Design Review Report  
The Grow House P80e

## The Grow House Higher Road, Longridge

Reference: PM\_2023\_007

Design Review Report  
**The Grow House P80e**

drawing title First Floor Plan as Proposed

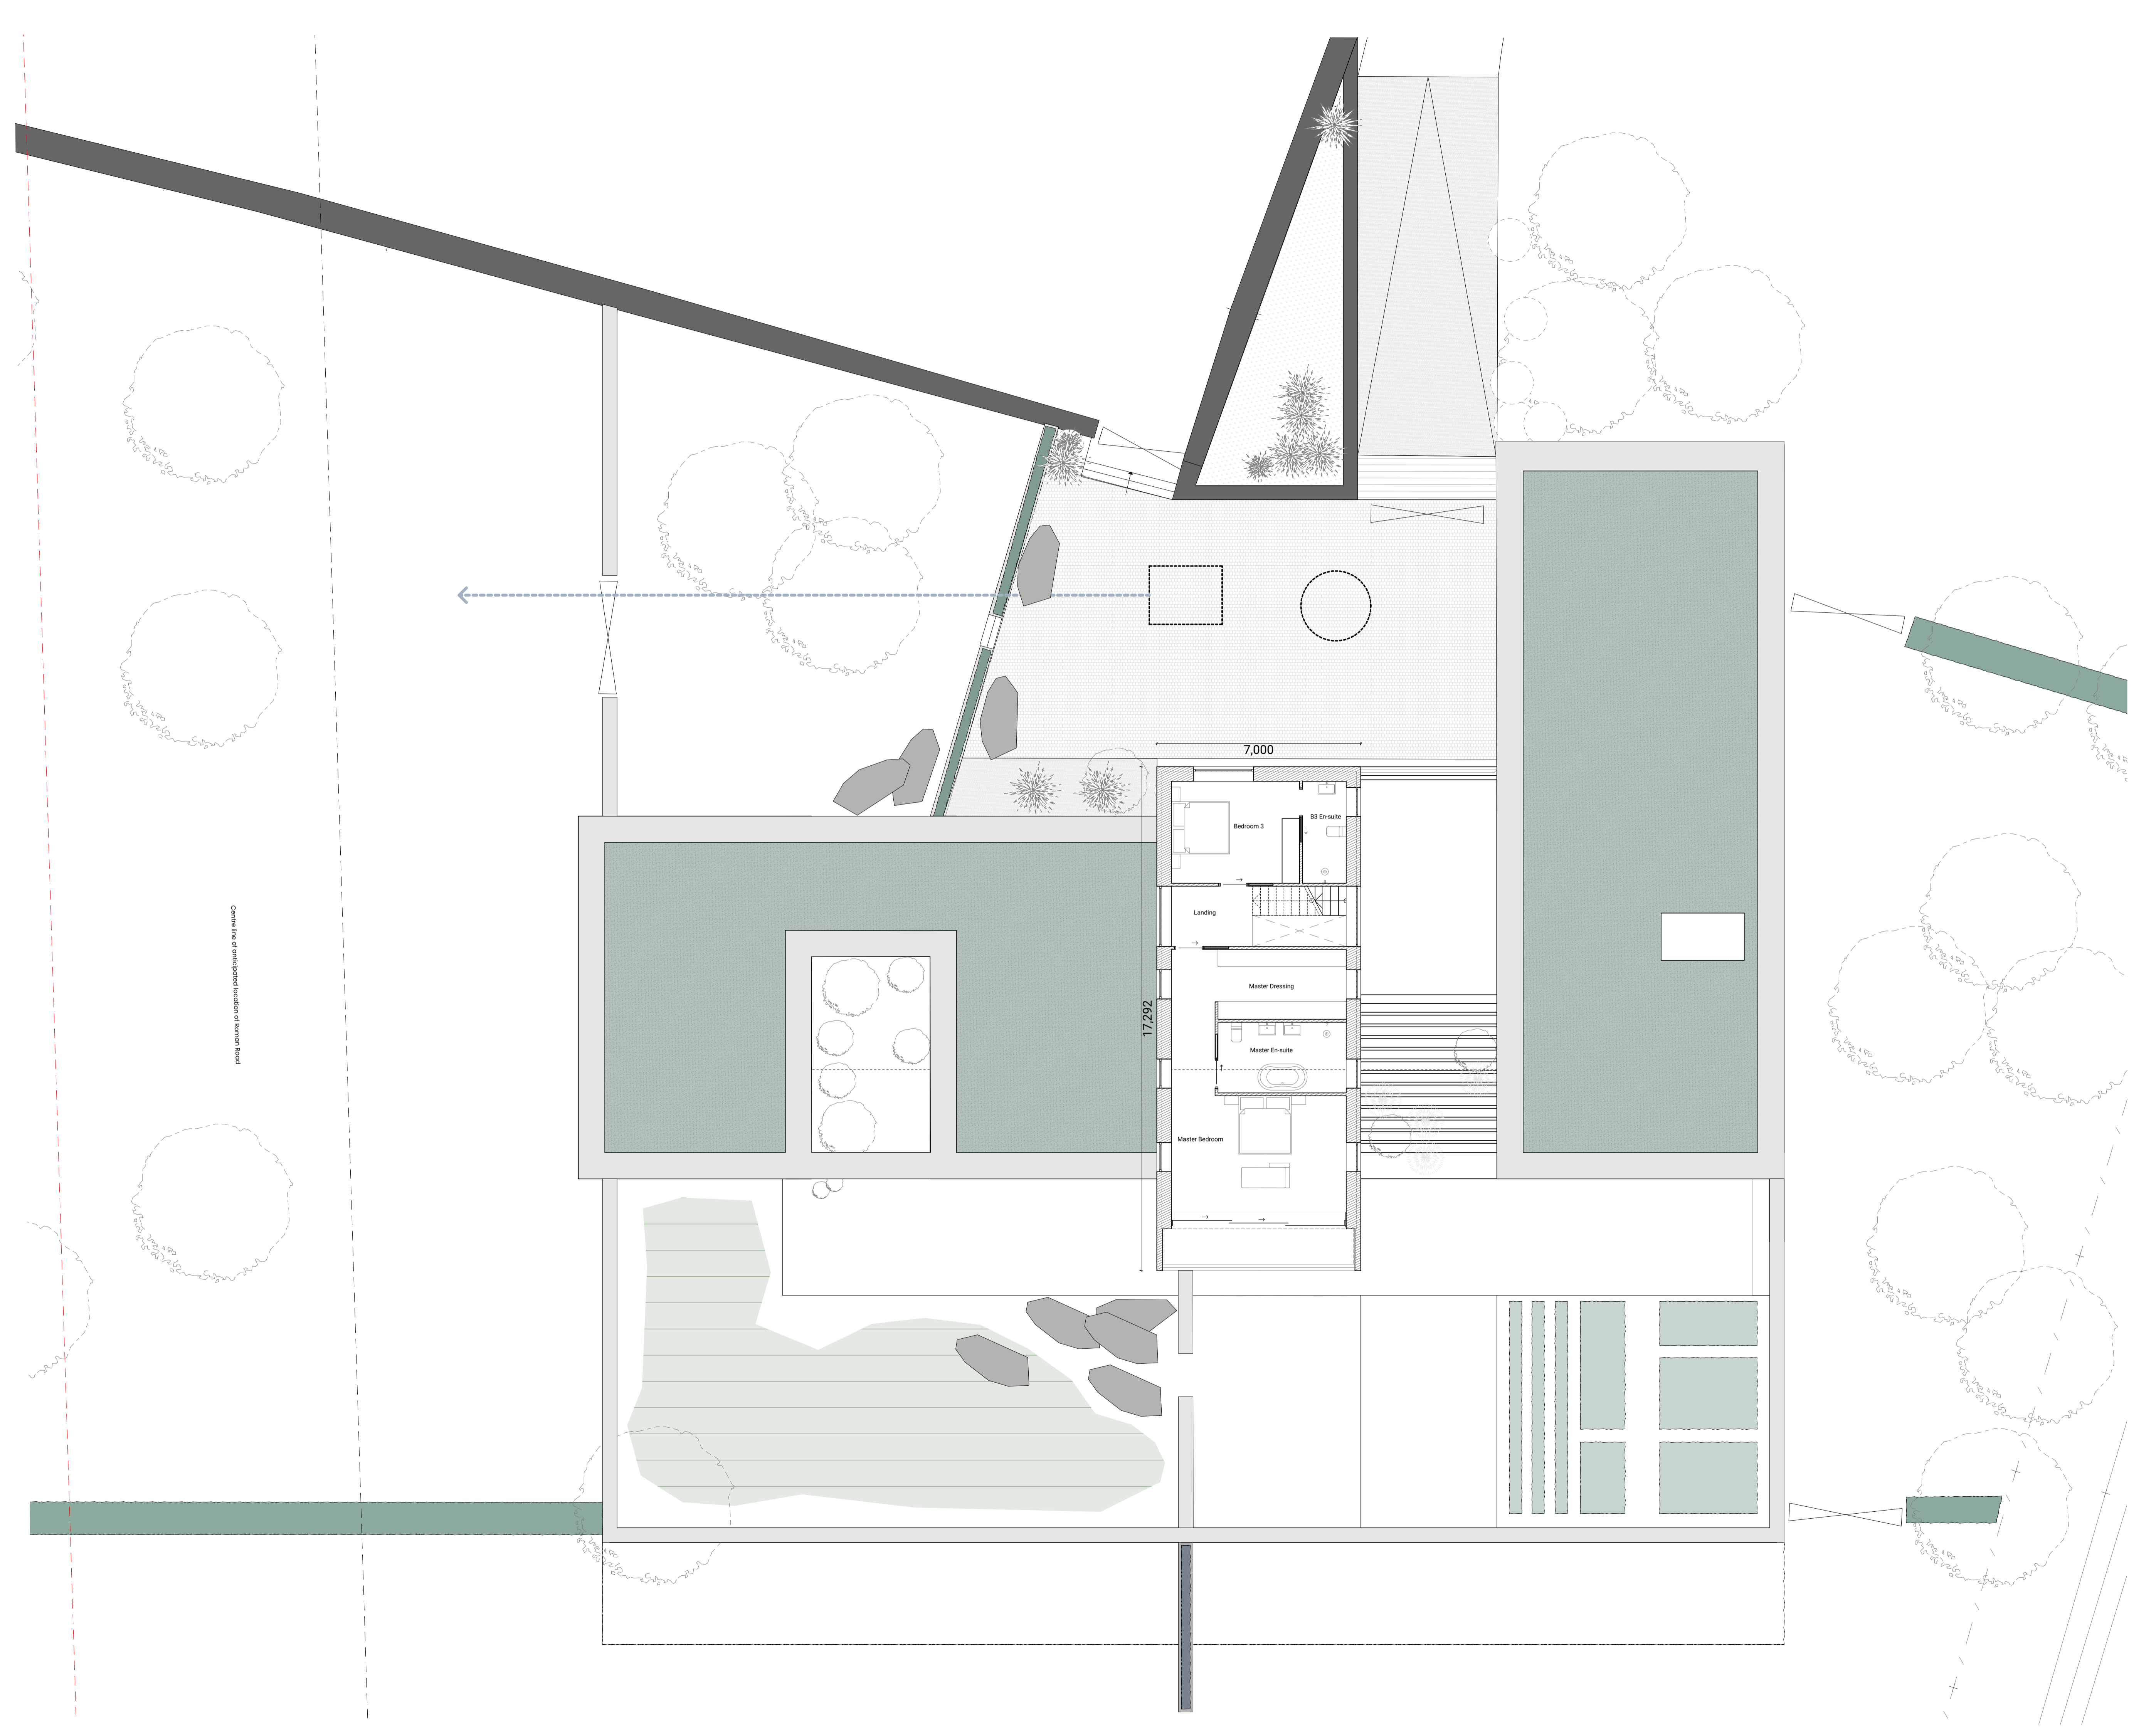
You were asked to consider mirroring the internal arrangements of the upper box, as this might help with the chimney arrangements and alignment. It might also offer the opportunity for egress on to the green roof and the spectacular views that would be seen from there.

- Inclusion of tall, narrow window(s) in the north elevation of the cantilevered upper floor (could be resolved by moving the bed to the opposite wall);
- consider vertical not horizontal timber to workshop door;

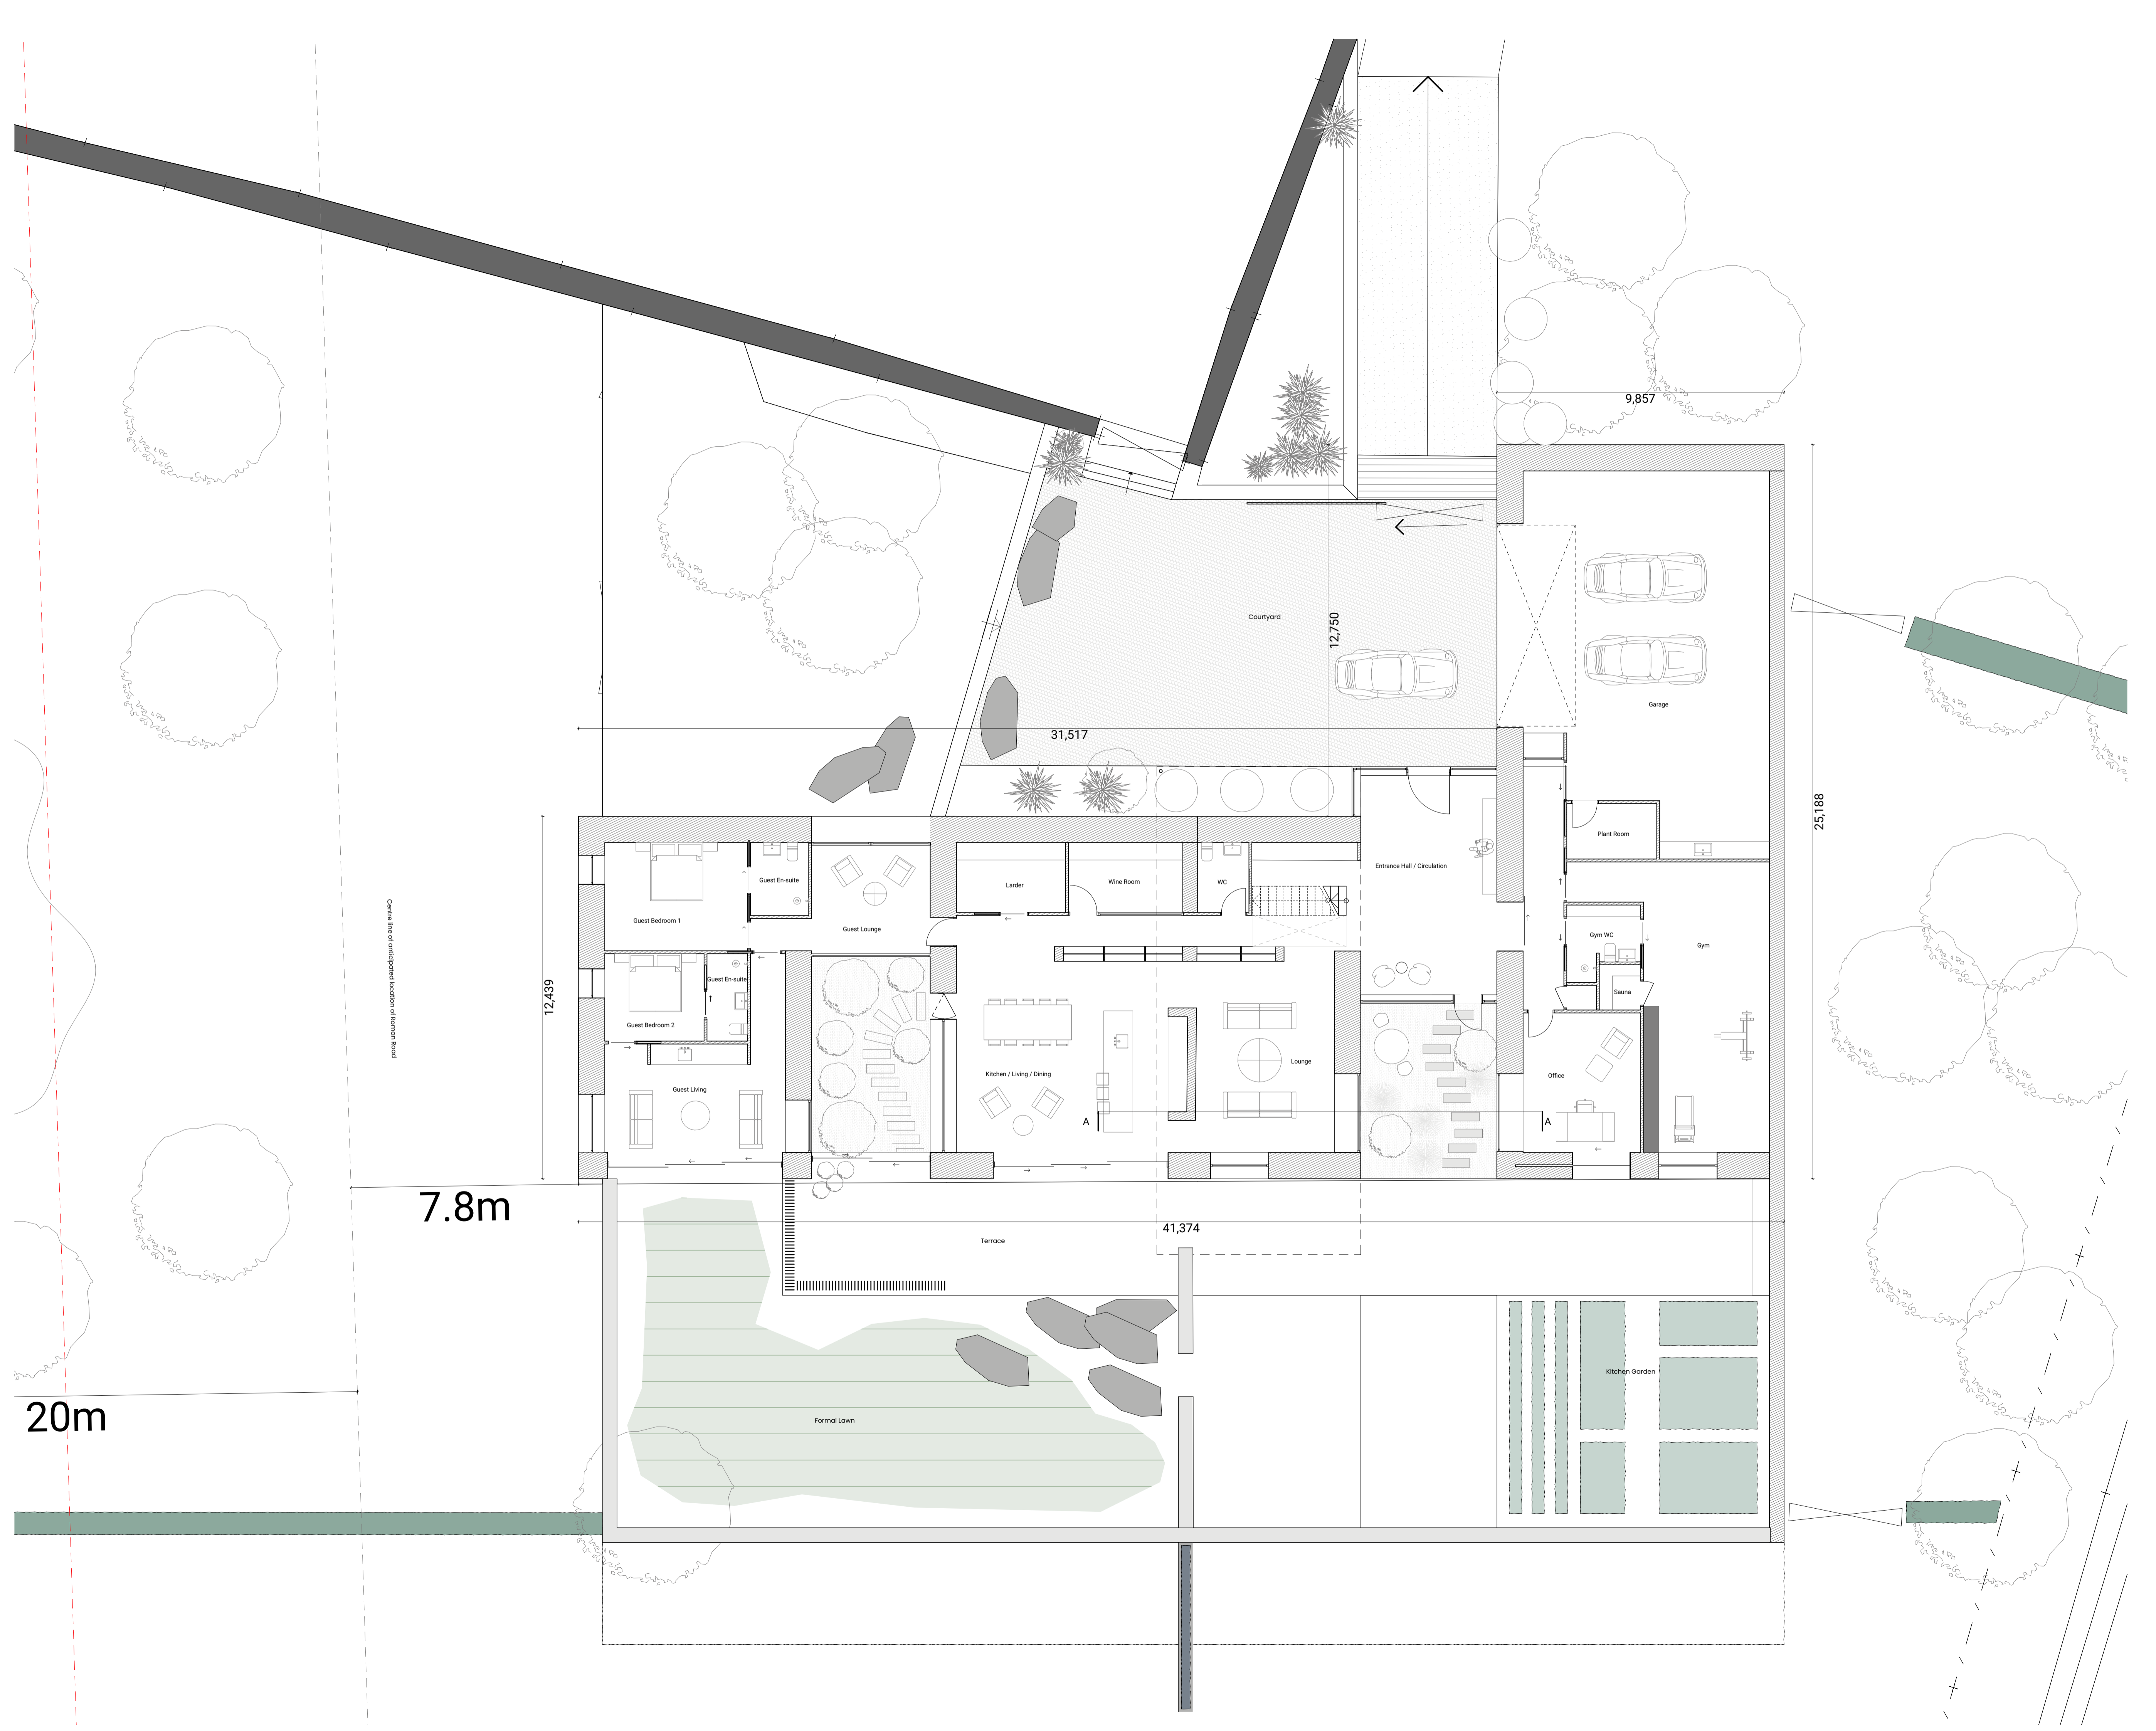
Whilst the ground floor plan was felt to be generally successful, you were asked to "take the labels off the plan and be sure just what all of the walls are doing". The notion of the elevated box being for bedrooms was questioned. This has the best views and you were asked to consider flipping the arrangement for the kitchen to East and linking that with a living area on the first floor, which would have the best views, but all in discussion with your client.

Section A-A (Through gabion cladding)

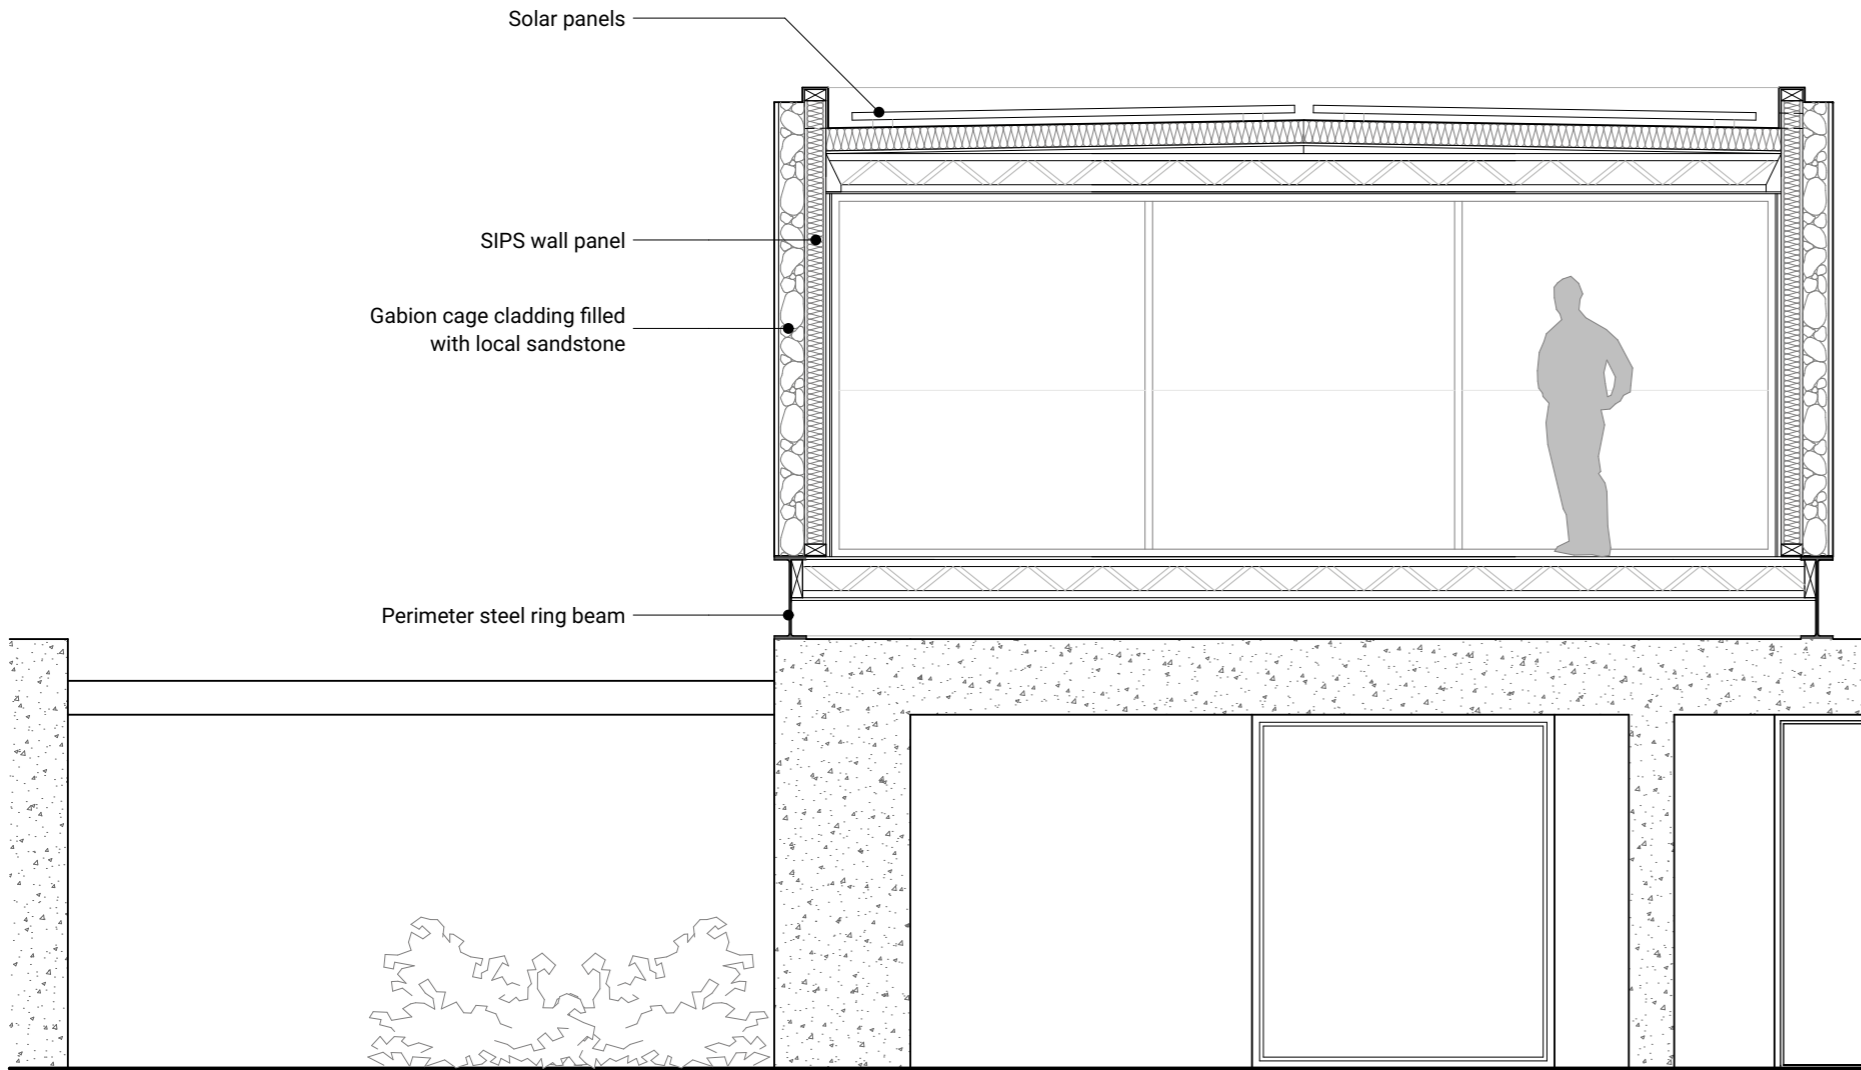
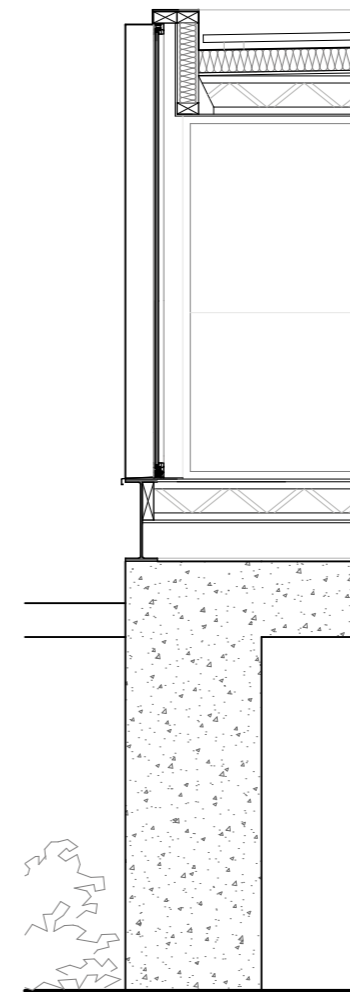
The required sections of the building are still missing and you need to “zoom in to the details”, for example to the edge of the roof, to ensure that this can be delivered with the required level of quality to elevate this way beyond any sense of it being a normal house.
